PLANNING CONSULTATION RESPONSE

Application No	2025/1000
Proposal	Proposed demolition of existing commercial/residential buildings and creation of new urban park to provide public open space and associated works.
Address	The Crescent, Cudworth, Barnsley, S72 8SY
Date of Consultation Reply	25 th March 2026
Consultee	Highways DC

[3rd Response]

**MARSHALLS RHINO GUARD - STAINLESS STEEL REMOVABLE PROTECTIVE BOLLARD**  
Scale 1:20

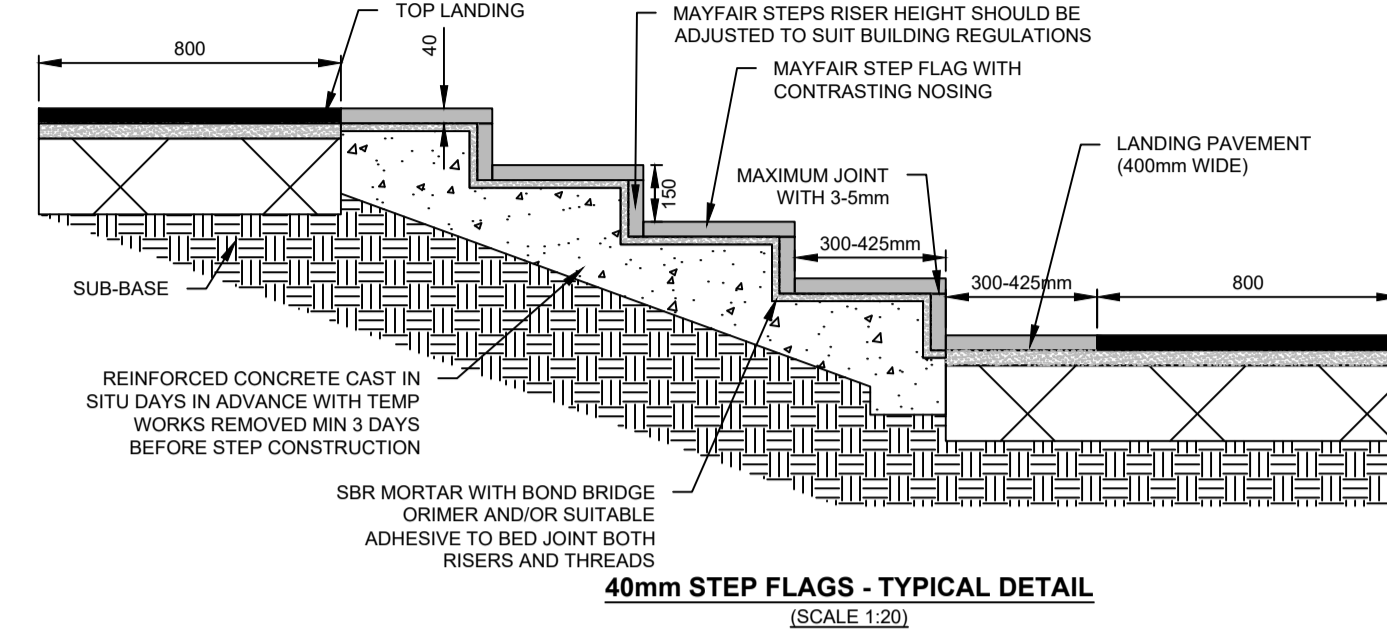
It is suggested that a 3.5t Transit tipper type vehicle would be used for the maintenance of the clock tower, planting and public realm; these vehicles typically have a length that ranges between 5.5m to 6.1m dependent upon the vehicle model. As such, the removable bollards are set back a sufficient distance to allow maintenance vehicles to pull up to the bollards without overhanging the carriageway of Barnsley Road.

Whilst the bollards are being removed/replaced, it is accepted that a waiting maintenance vehicle would be at least partly blocking the footway, however, a continuous safe route for pedestrians would remain available through the public open space.

With regard to the second row of removable bollards towards the north-east corner of the site, it has been clarified that this is not to be a vehicular access and an extension to the existing dropped kerb is therefore not required.

Prior to the development being brought into use, the scheme for the provision of removable bollards shall be fully implemented and thereafter retained and maintained in good working order for the lifetime of the development.
